## ASSESSMENT REPORT

Kings Forest, Tweed  
MP 08\_0194 MOD 3

The modification seeks approval to remove the rural supplies building in Precinct 1 and replace it with a service station, a station shop, six food and drink outlets including two drive throughs and an associated dining area, and a car and dog wash. The modification request also seeks approval to remove the 10 metre (m) wide agriculture buffer on the northern boundary of the site.

GROUND FLOOR PLAN  
1:250

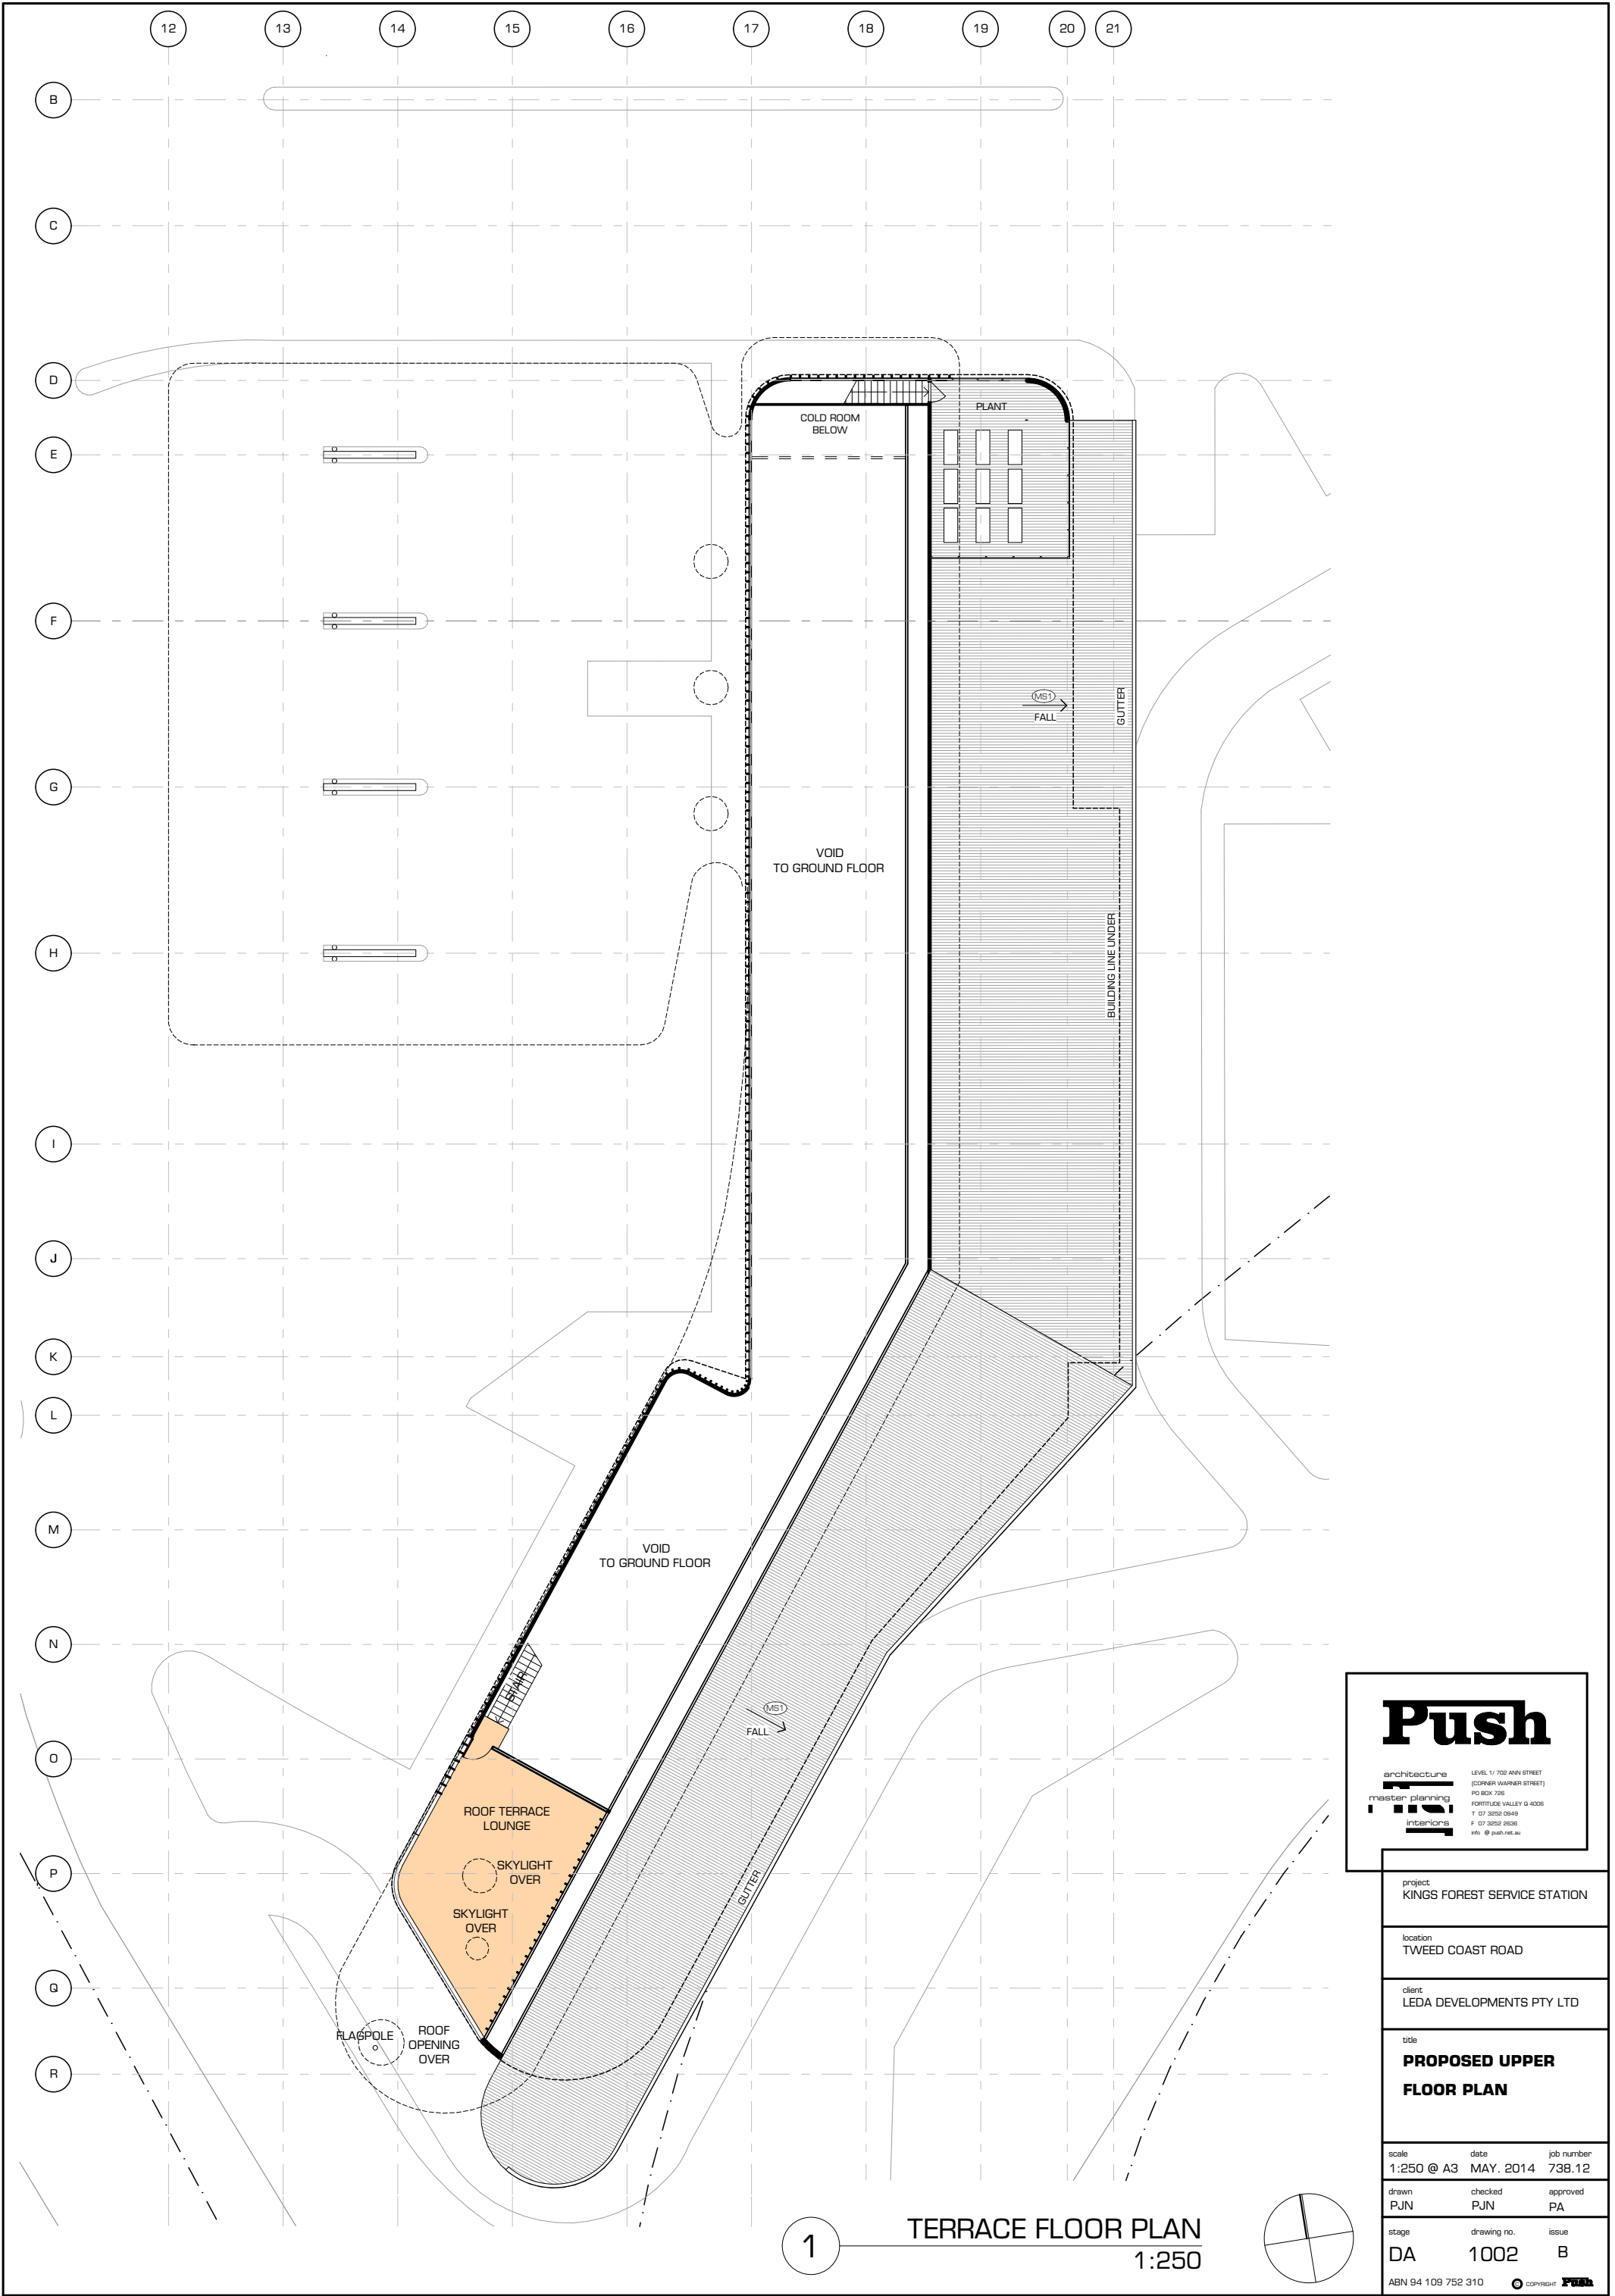
- it would introduce new noise (associated with vehicles idling in the drive-through and the use of roof top outdoor dining areas), odour (associated with petrol vapours and the preparation of food on-site) and air quality impacts (associated with the operation of the proposed petrol bowzers and CO, CO<sub>2</sub> and volatile organic compound (VOCs) emissions from additional cars and trucks accessing the site), all of which would occur 24-hours-per-day, seven-days-per-week;

- it would introduce land uses that are sensitive to the application of agricultural pesticides (takeaway food and drink premises, outdoor dining areas, and drive through facilities) and would significantly increase the risk of land use conflict in comparison to the approved project; and

Drawn PN Stage DA Drawing No. 2001 Issue D

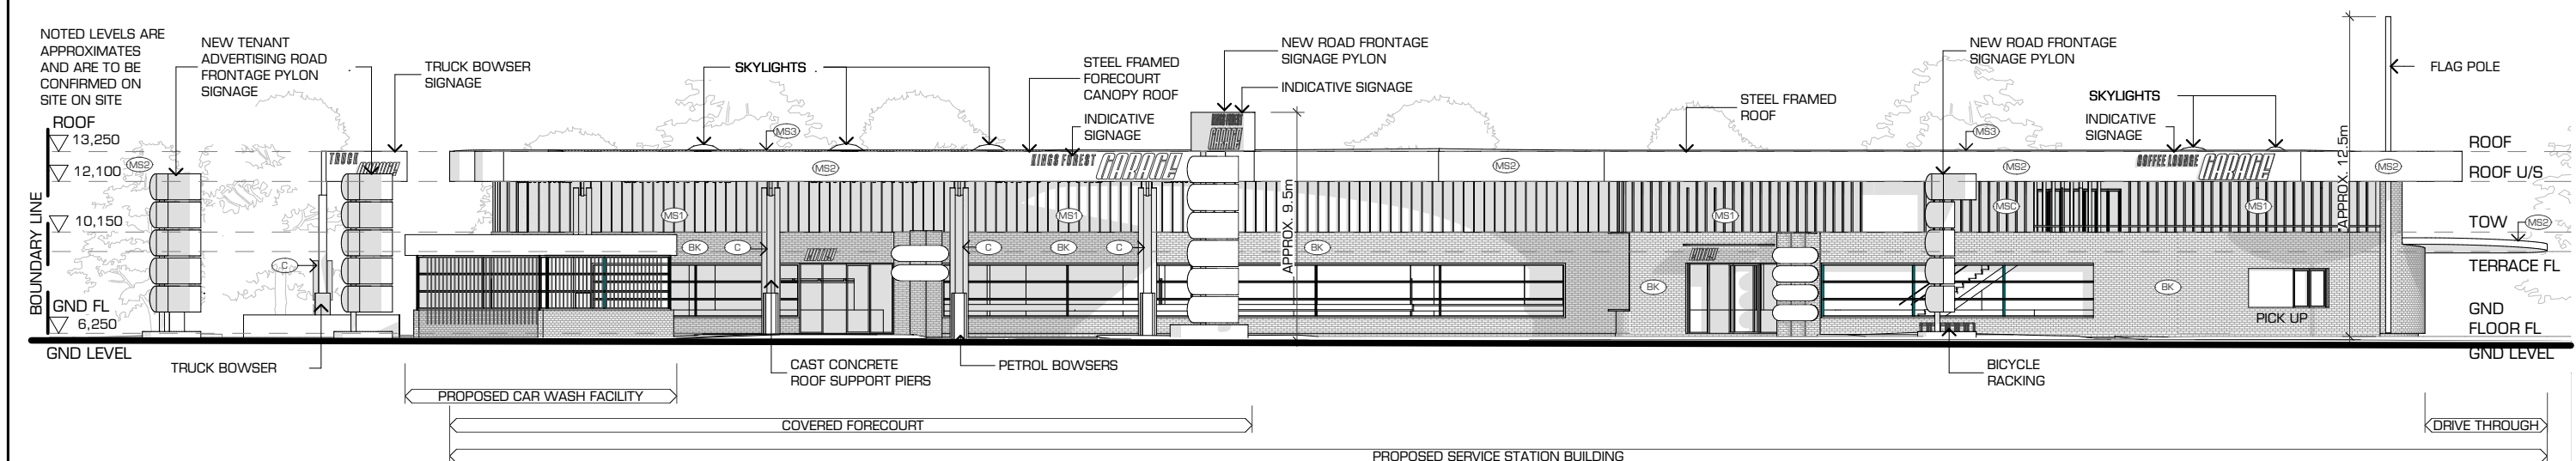
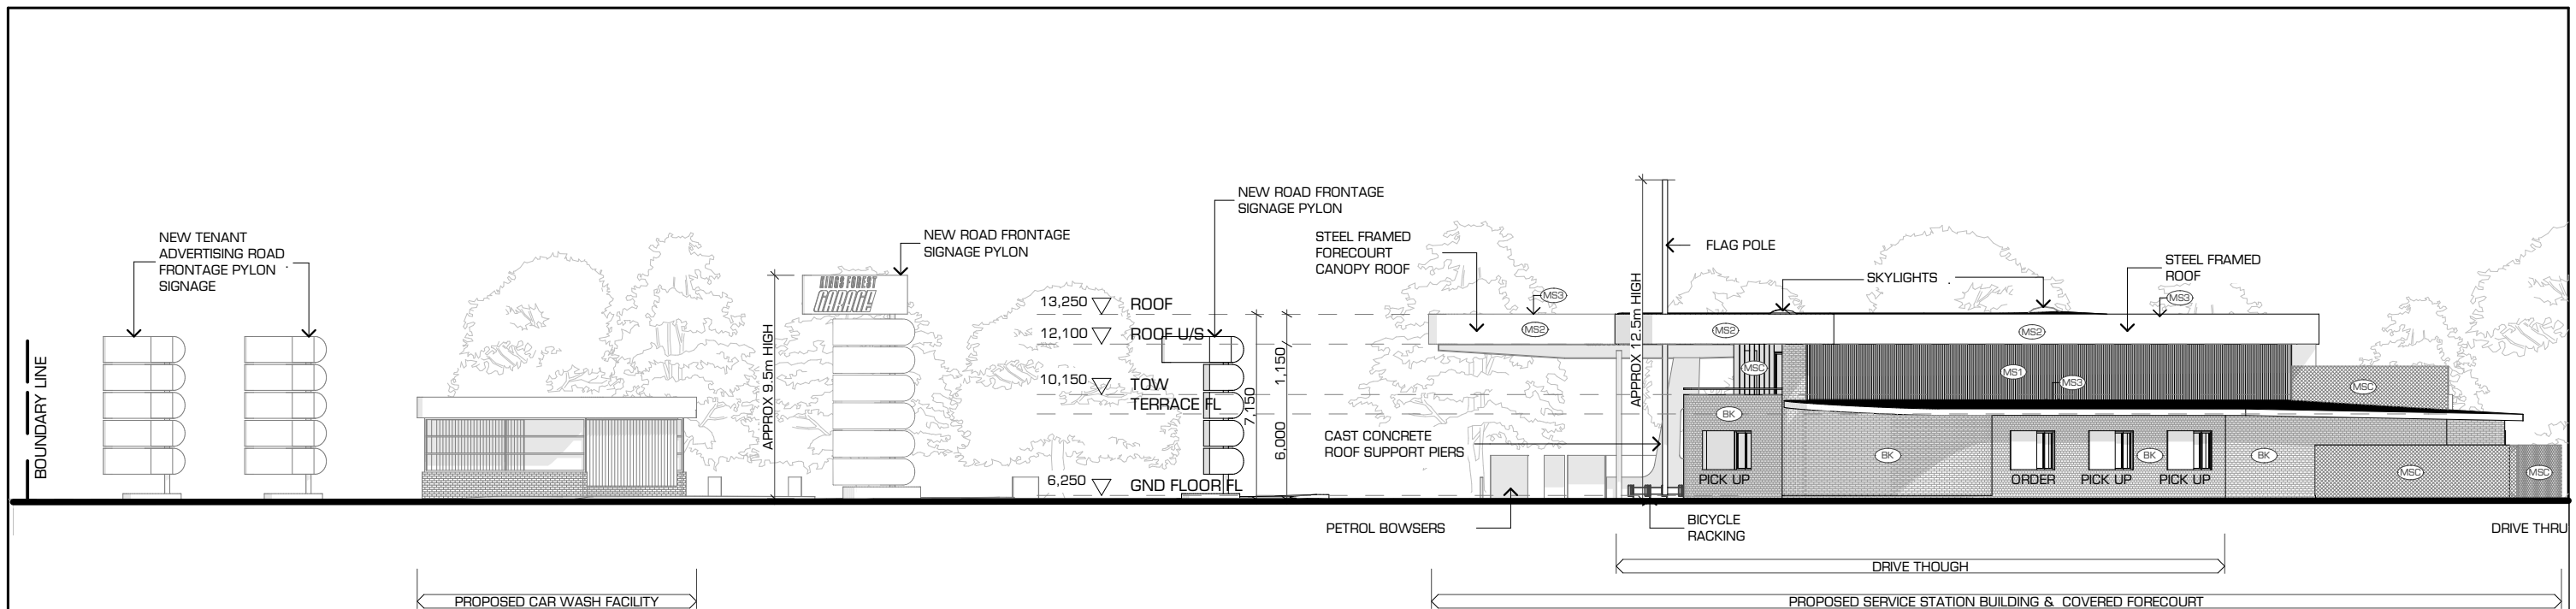
- increased bulk and scale when viewed from Tweed Coast Road and the surrounding residential premises as it will introduce large contiguous canopy structures, petrol bowzers, new illuminated pylon signage and will move the built form closer to Tweed Coast Road (see **Figure 13**).

- the size, number and location of the proposed signs would result in significant visual clutter and light-spill which would detract from the rural character of Tweed Coast Road (see **Figures 11 to 13**);
